Located At 22 MONUMENT SQ

Job ID: 2012-10-5134-ALTCOMM

has permission to Install of new wall canopy grease exhaust hood with front discharge makeup air-1000CFM exhaust fan provided that the person or persons, firm or corporation accepting this permit shall comply with all of the provisions of the Statutes of Maine and of the Ordinances of the City of Portland regulating the construction, maintenance and use of the buildings and structures, and of the application on file in the department.

1. Application approval based upon information provided by the applicant or design professional, including revisions dated received 10/19/12. Any deviation from approved plans requires separate review and approval prior to work.
2. The hood, duct and exhaust shall be installed per NFPA 96. This permit is approved based on the plans submitted and/or updated for reductions in the clearances based on the application of a UL approved fire wrap or equivalent assembly per code.
3. Separate permits are required for any electrical, plumbing, sprinkler, fire alarm, HVAC systems, heating appliances, including pellet/wood stoves, commercial hood exhaust systems and fuel tanks. Separate plans may need to b

Drawing file: 2012-10-5134 ALT-COMM-HOOD / David's Restaurant - Elevation View.pdf

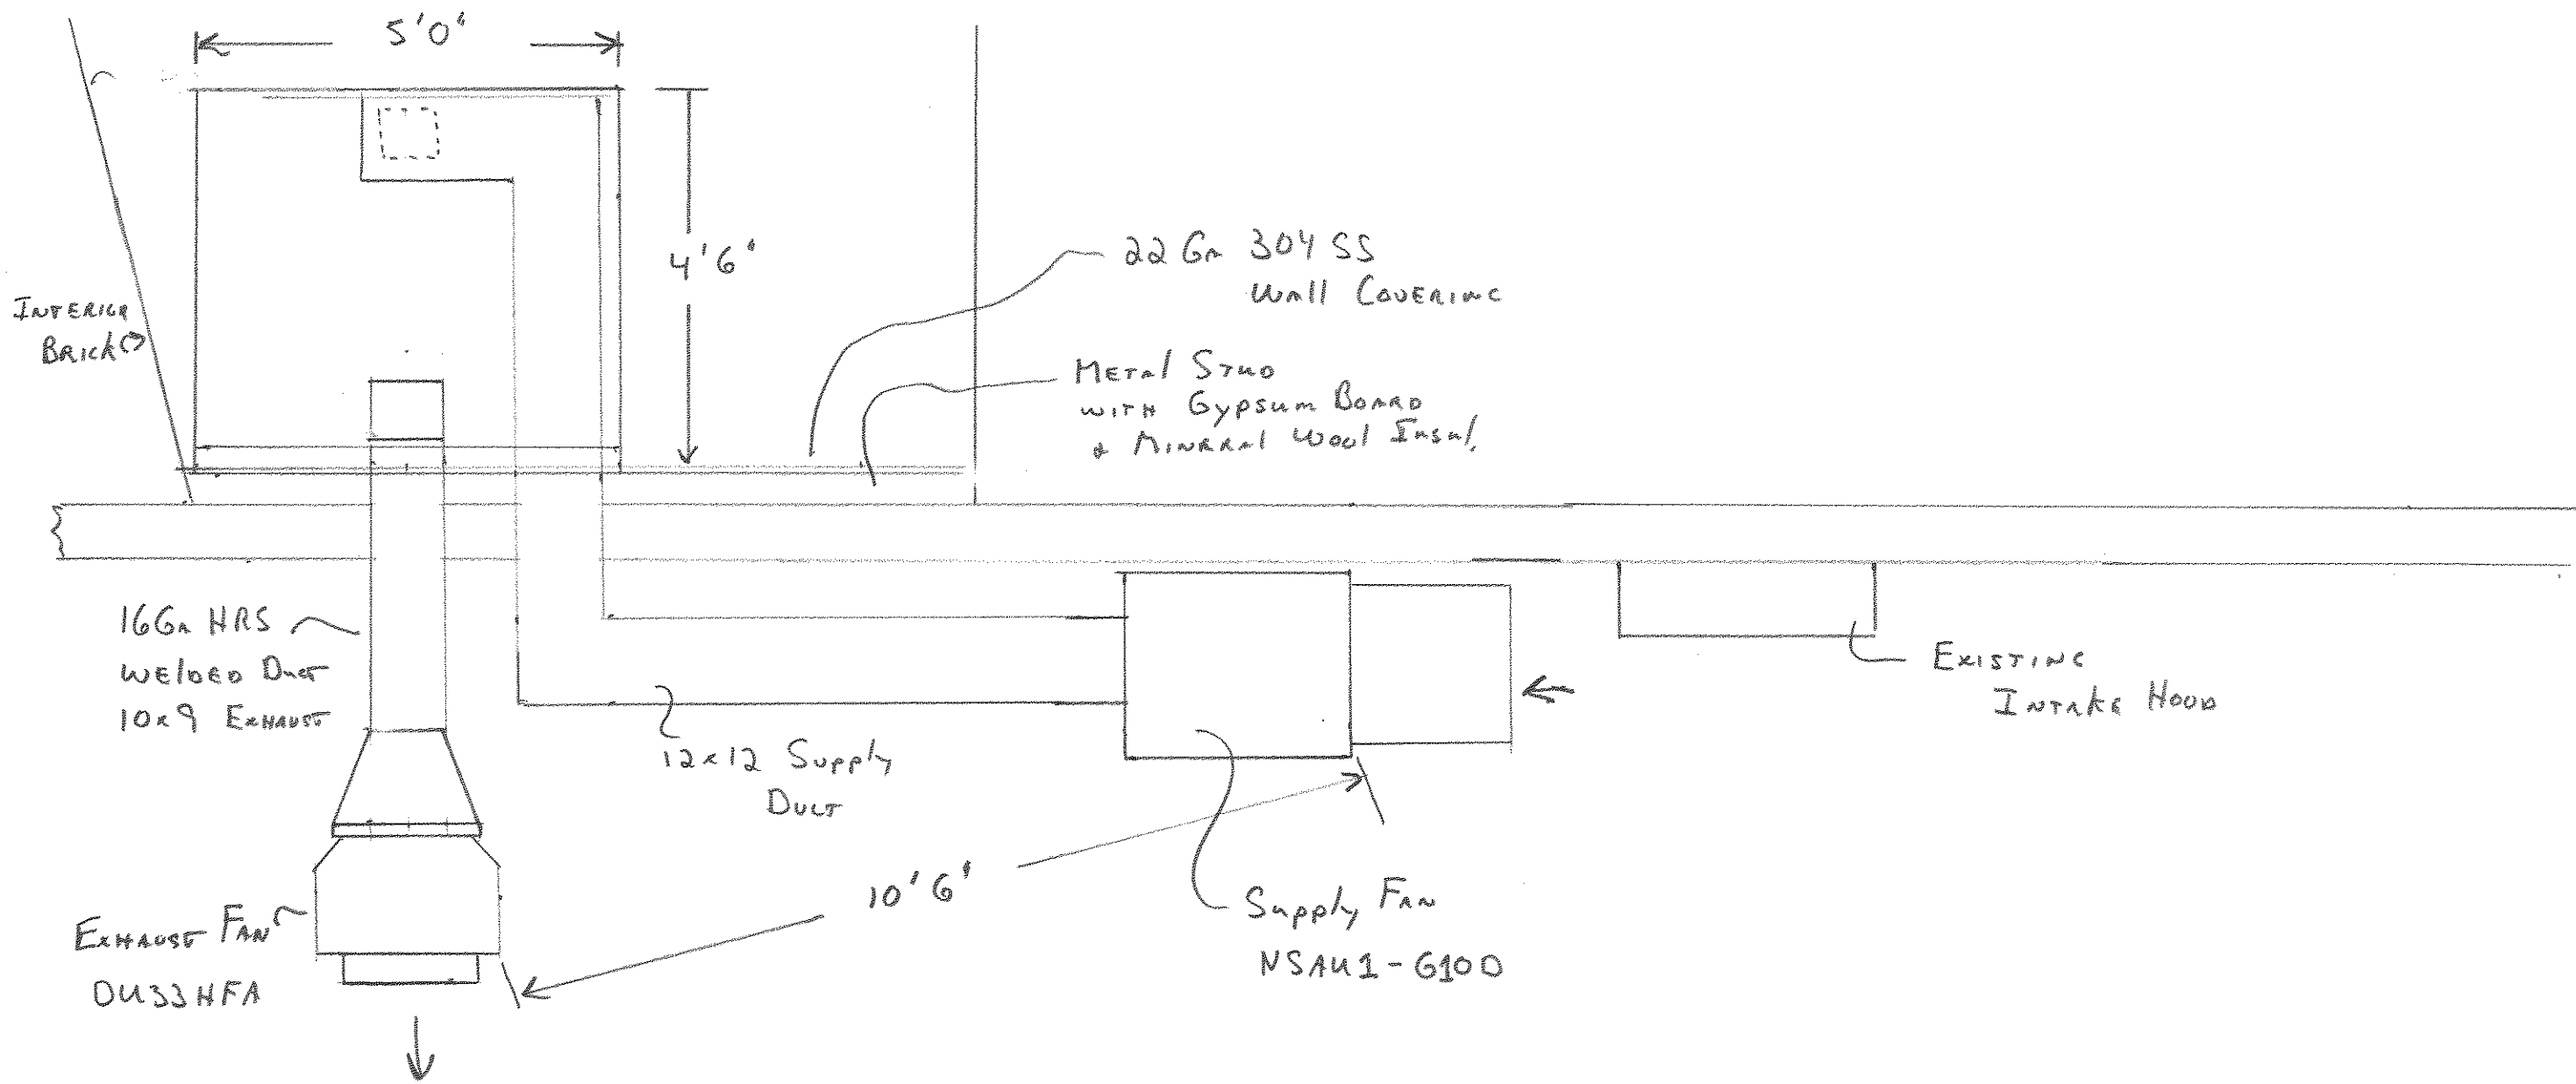
This will be acceptable as long as the air velocity calculations satisfy the removal of grease and smoke vapors. Can you confirm that with the additional length of duct that this will be sufficient?

The velocity thru the new 10 x 9 duct is 1650 FPM, this is sufficient to exhaust the grease and smoke vapors.
